Bramford – Twinstead:

Deadline 10

Braintree District Council (20041141) &

PINS REFERENCE: EN020002

Reproduced from ordnance survey maps by permission of the
 Ordnance Survey on behalf of the controller of her majesty's
 stationery office.
 © Crown copyright Ordnance Survey, Licence no. 0100052046.

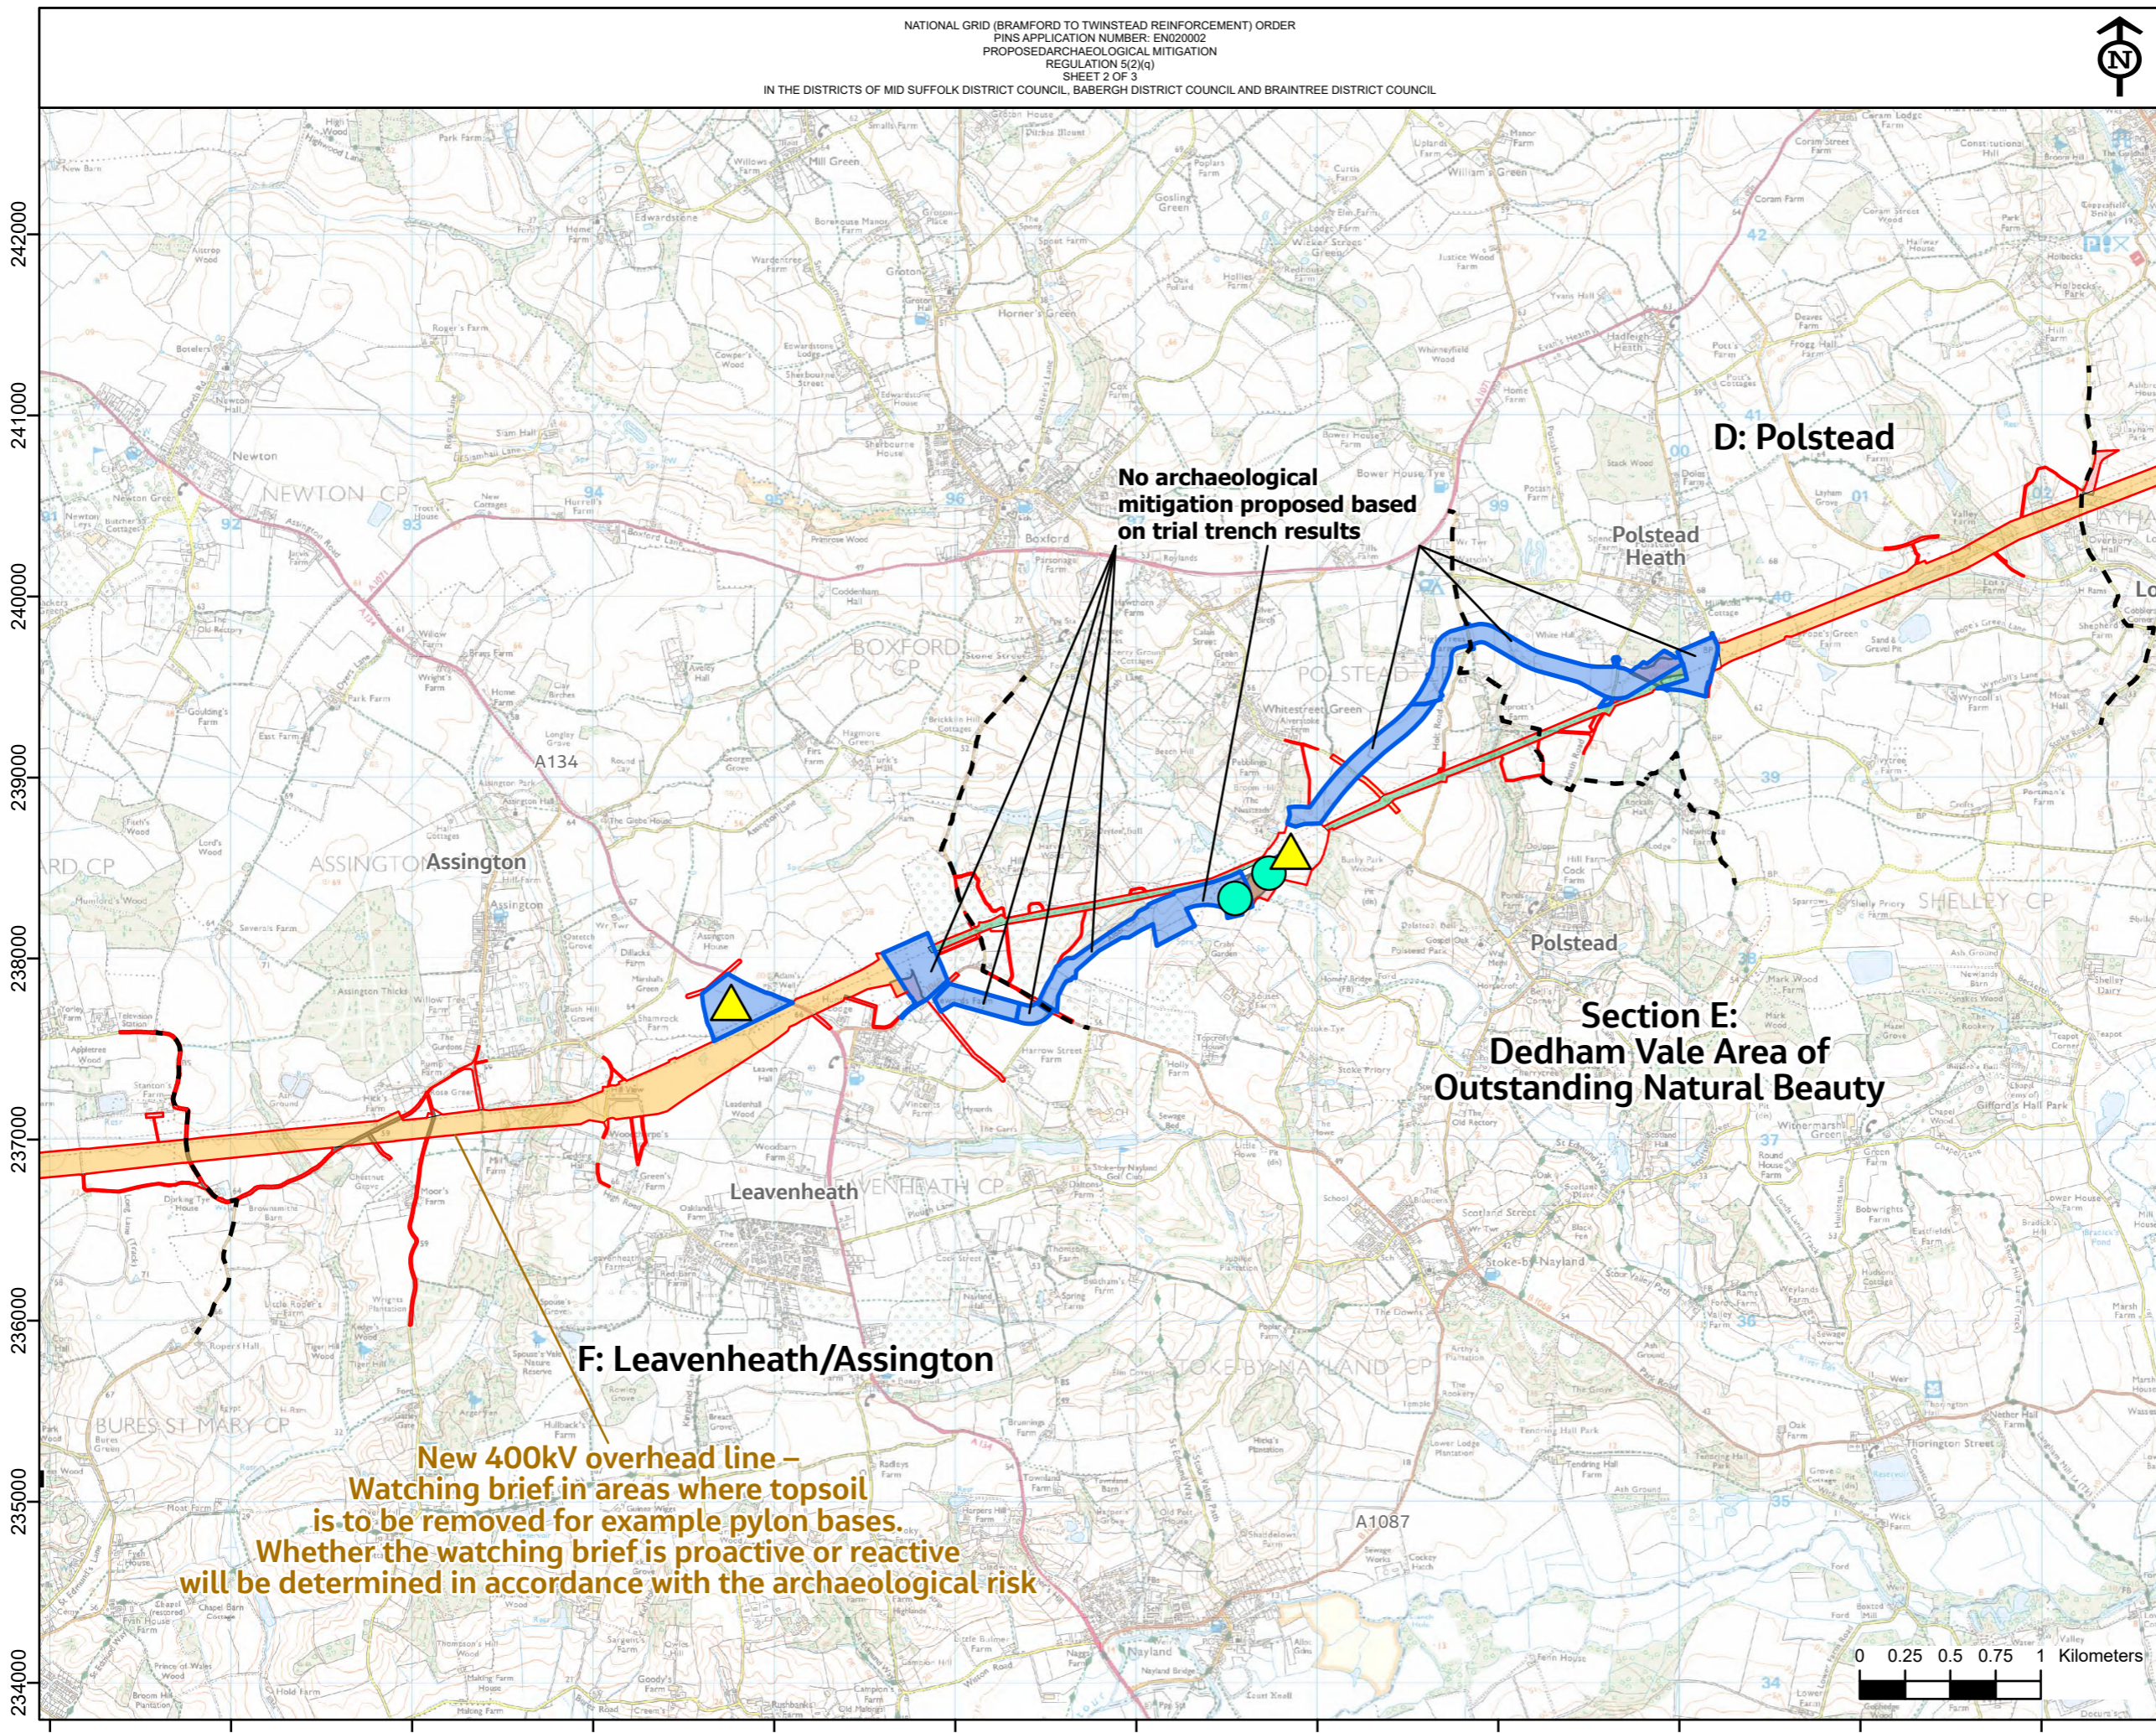
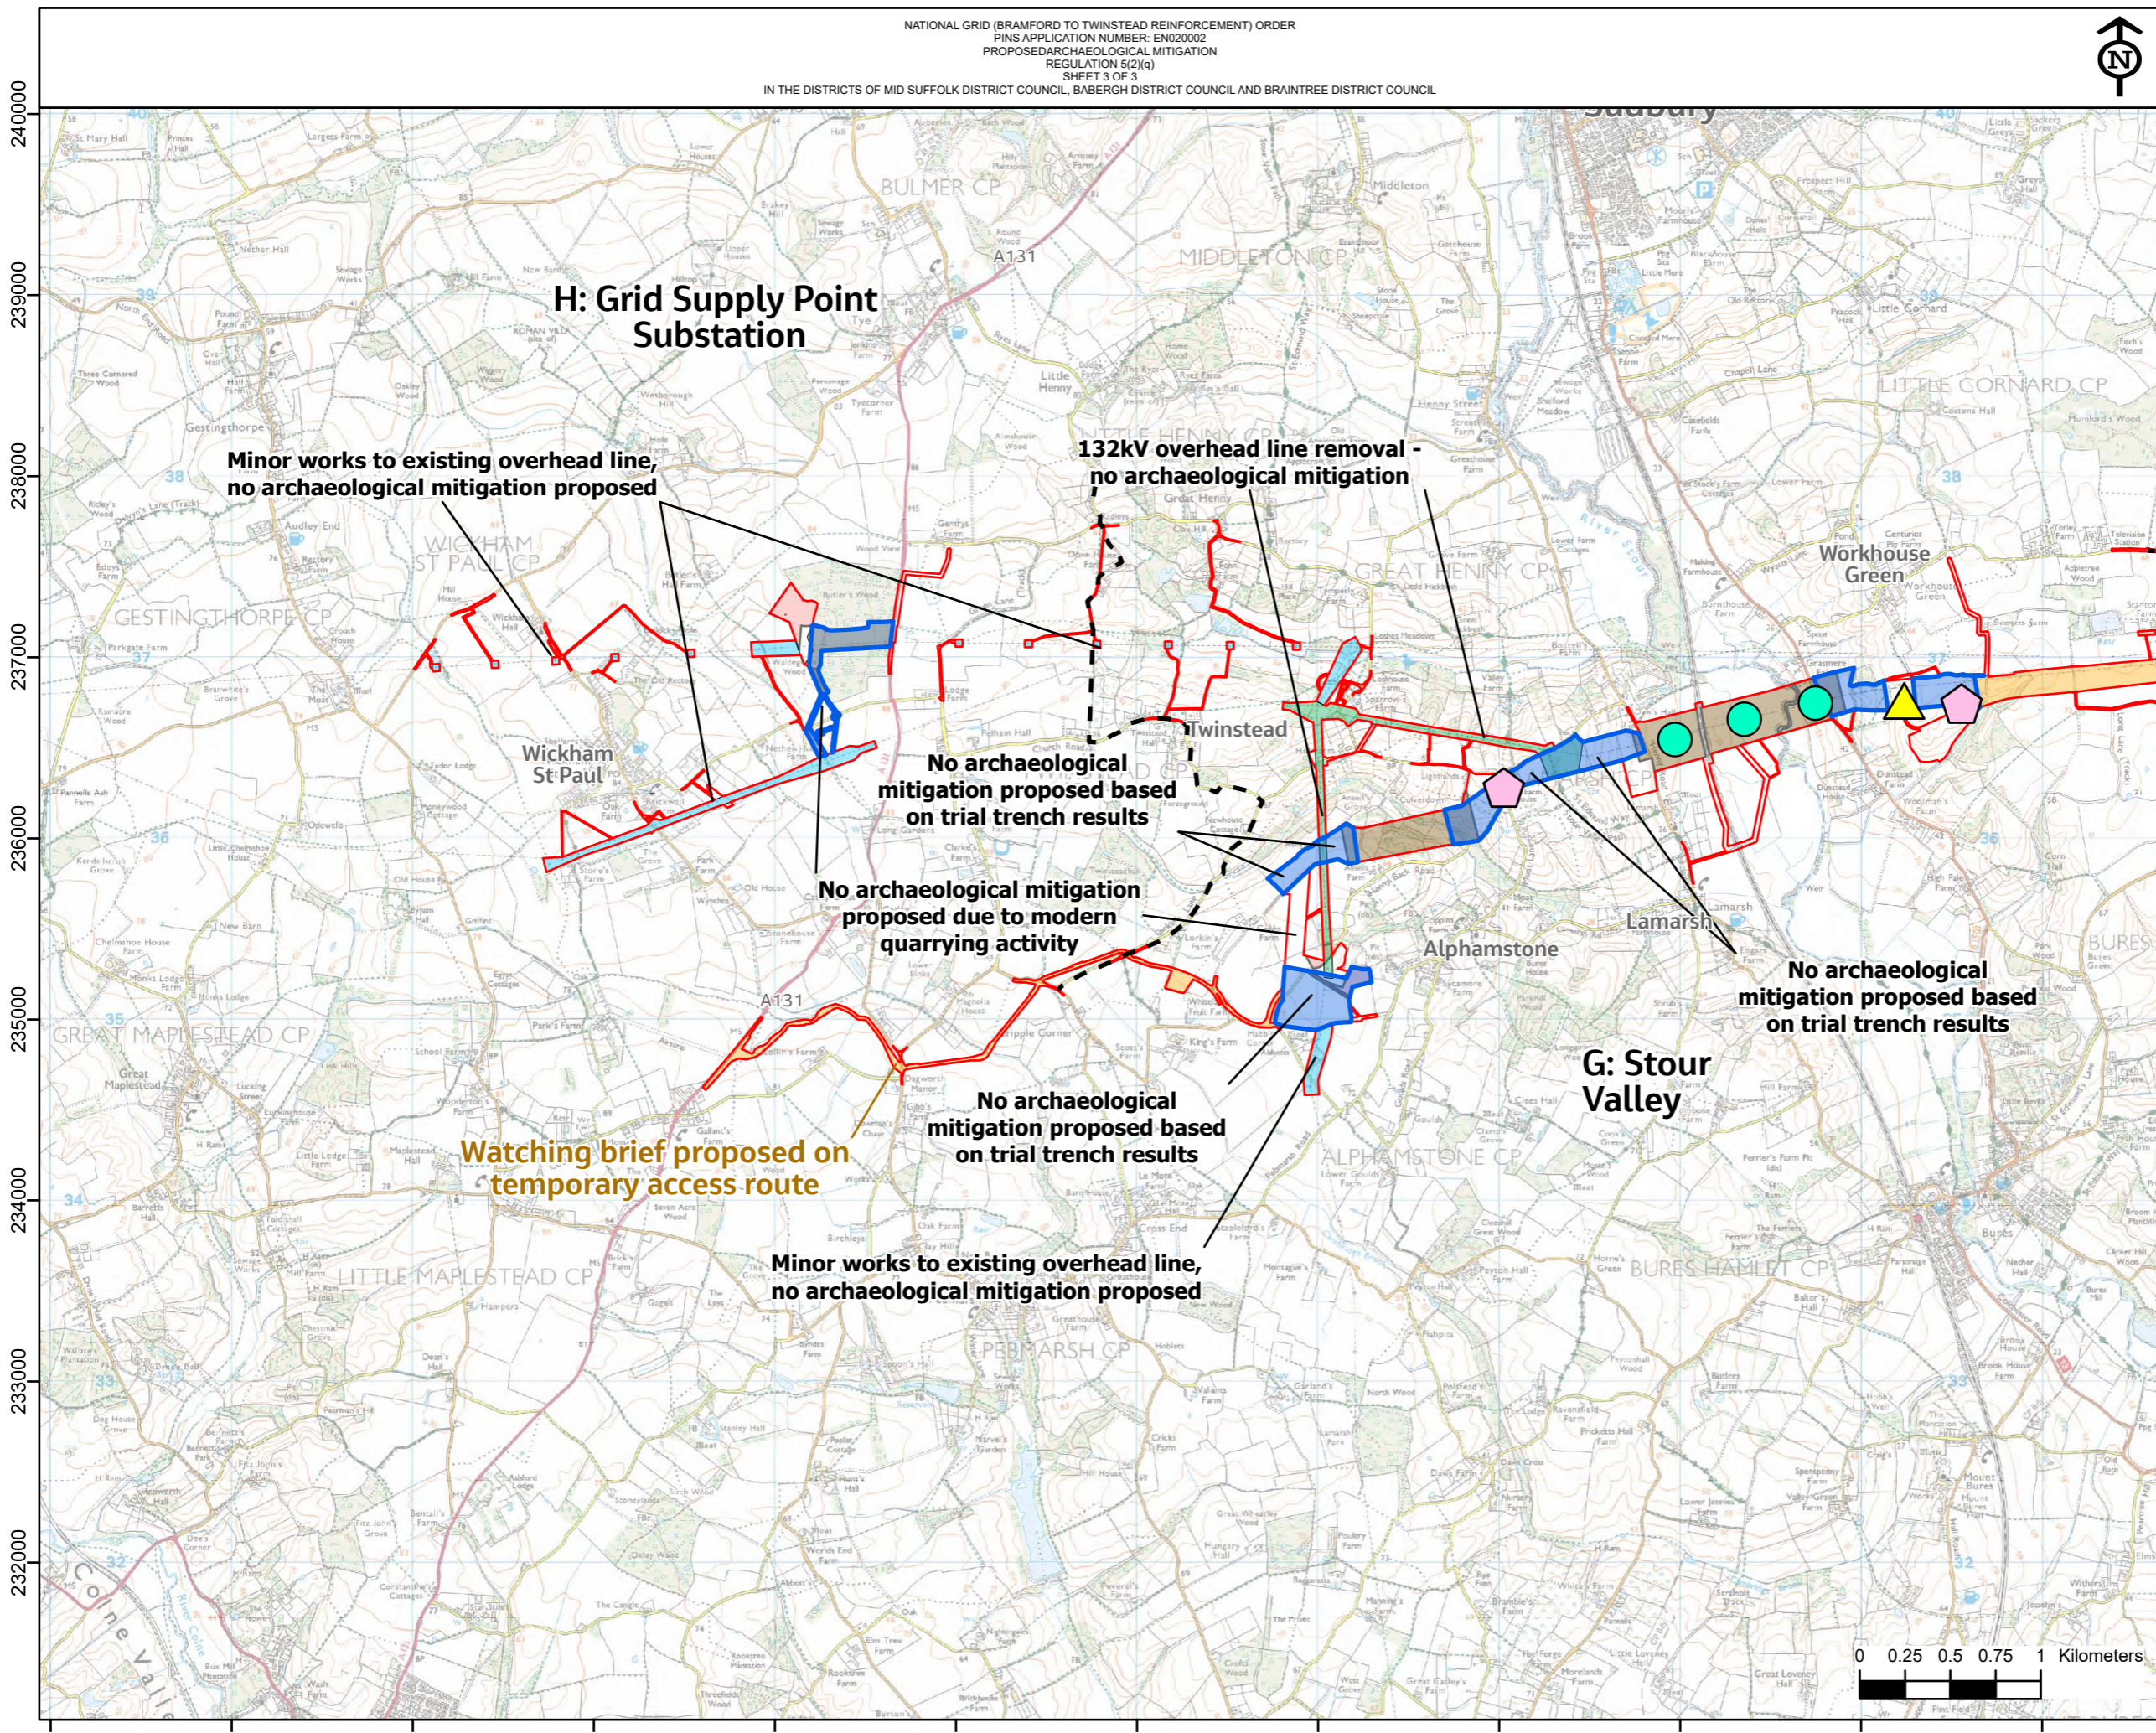
- 4.3.5 The Applicant has failed to provide sufficient information to identify areas that can be removed from the requirement for further archaeological work or mitigation at this time.

- 4.3.6 Removing areas from further investigation at this stage without adequate supporting evidence is contrary to what is stated in Document 6.2.8 Environmental Statement Ch 8 Historic Environment Section 8.8.2 which states that “ a level of archaeological mitigation would be applied to all archaeological remains where removal or damage is unavoidable, whether significant or not, as per good practice”.

- 4.3.7 In addition, mitigation is proposed in areas which have not been subject to any archaeological evaluation such as access roads, temporary compounds, planting etc. Archaeological monitoring and recording would not be recommended on areas where the potential for archaeological remains is unknown. These areas should be the subject of an archaeological evaluation by trial trenching in the first instance. This would allow a suitable mitigation strategy to be proposed.
